**WELWYN HATFIELD BOROUGH COUNCIL
EXECUTIVE DIRECTOR - PLANNING, PUBLIC PROTECTION AND GOVERNANCE**

DELEGATED APPLICATION

Application No: 6/2017/0430/LAWE
Location: The Warren, 8 Carbone Hill Northaw Potters Bar EN6 4PL
Proposal: Certificate of lawfulness for existing outbuilding to be ancillary to the existing dwelling
Officer: Mr S Dicocco

Recommendation: Refused

Job No 732 Drawing No PD10 A

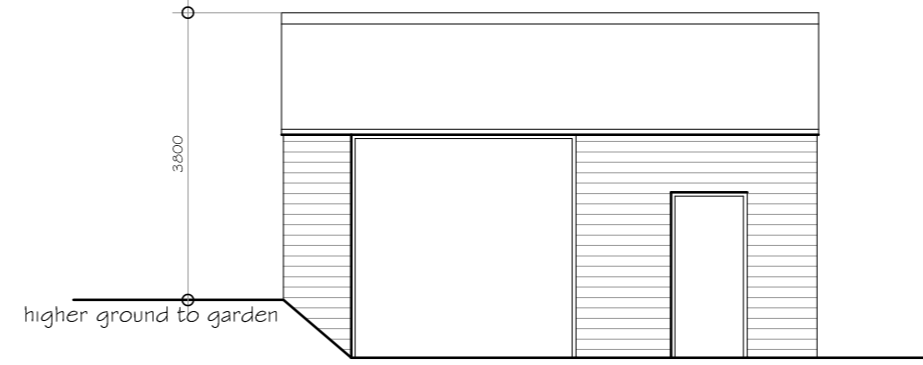
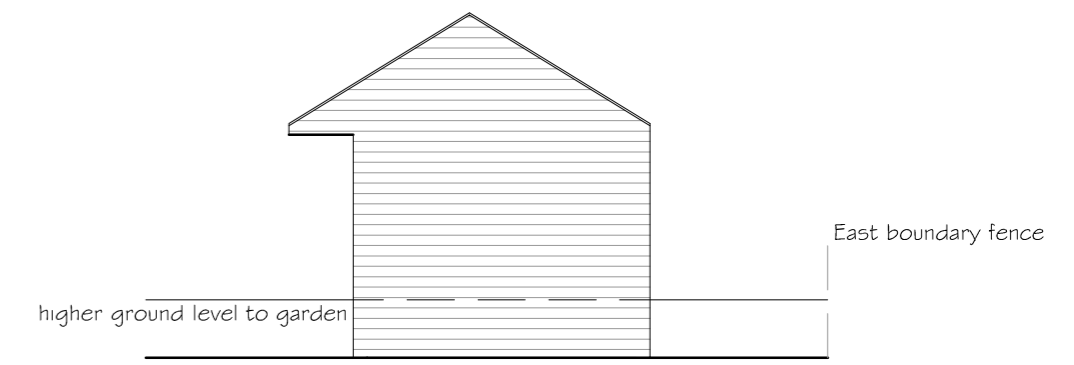
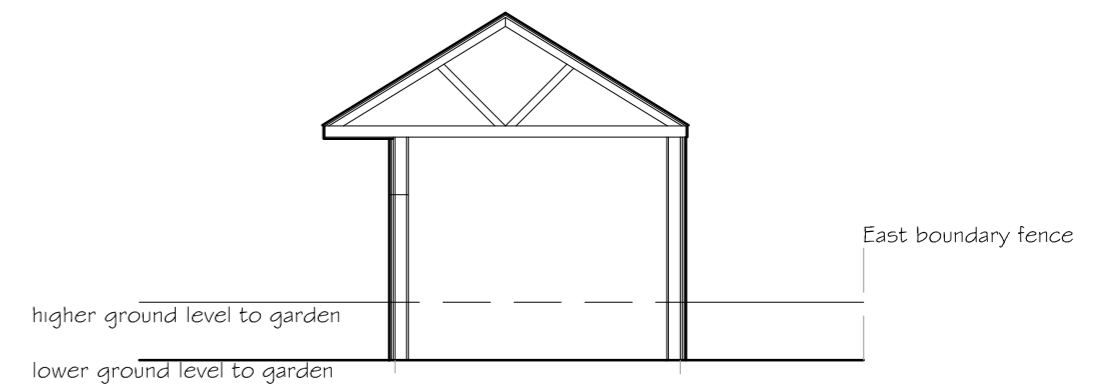
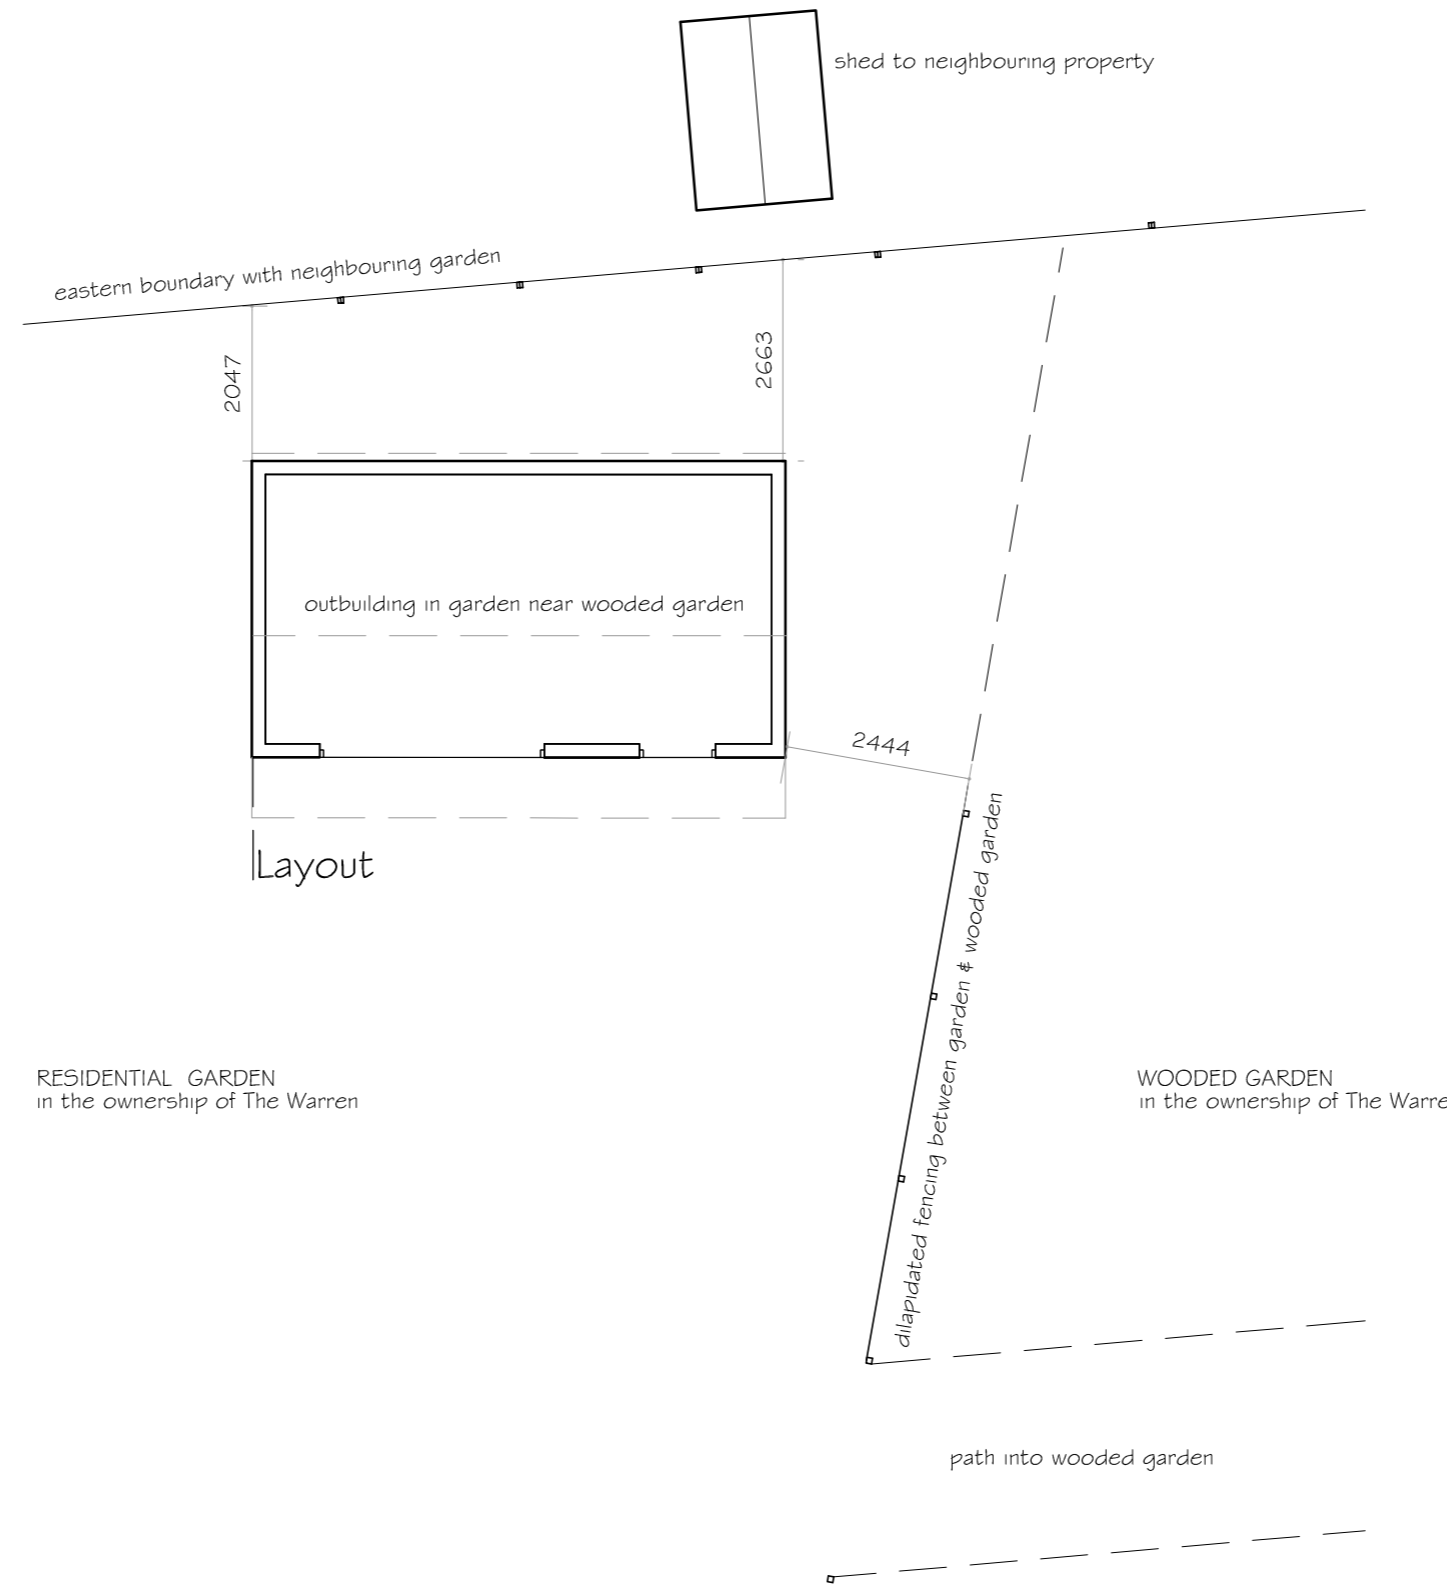
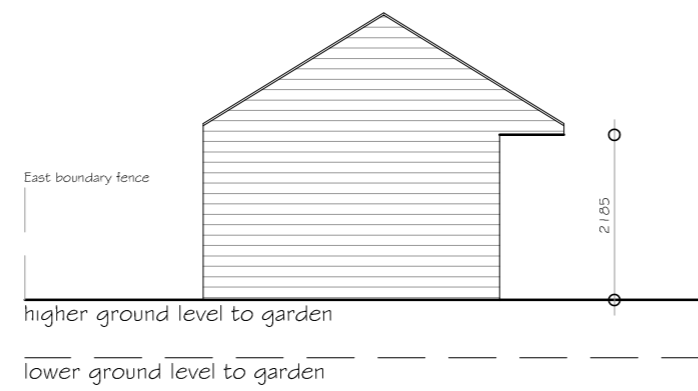
It is noted that the building is constructed on an uneven surface. In accordance with page 43 of the Permitted development rights for householders: Technical Guidance, *“the height of the building ... should be measured from the highest ground level immediately adjacent to the building to its highest point”*. Accordingly, the height of the building, as well as the height of eaves, have been measured on site, and indicate that the measurements provided within the drawing Number PD10A are accurate.

The photographs taken on site show that the fence has been manipulated to the south east of the outbuilding to show a 2m spacing in order to comply with the height limitations within paragraph E.1(e) of Schedule 2, Part 1, Class E of the Town and Country Planning (General Permitted Development) Order 2015 (as amended). Whilst it is accepted that a residential curtilage, on a fact and degree basis, is malleable over time, the evidence gathered on site does not indicate that a sufficient amount of time has passed in order to assimilate the land to the south east of the shed into the residential curtilage.

By virtue of the proximity of the outbuilding to the boundary of the curtilage of the dwellinghouse, the outbuilding is limited in height by paragraph E.1(e)(ii) of the Town and Country Planning (General Permitted Development) Order 2015 (as amended) to 2.5m in height. The outbuilding as measured from the highest ground level is approximately 3.8m

in height, thereby exceeding the limit in height imposed by the buildings proximity to the boundary of the curtilage of the dwellinghouse.

1. The height of the building would exceed 2.5 metres in the case of a building within 2 metres of the boundary of the curtilage of the dwellinghouse. The building as it exists fails to comply with the height limitation contained within paragraph E.1(e)(ii) of Schedule 2, Part 1, Class E of the Town and Country Planning (General Permitted Development) Order 2015 (as amended). No evidence has been put forth to suggest that the building has been in-situ for a period of time exceeding the time limit for enforcement action on operational development defined within section 171B of the Town and Country Planning Act 1990 (as amended). The Local Planning Authority are not satisfied that the operational development involved in the erection of the outbuilding would have been lawful at the time of application, and as such, the application should be refused.
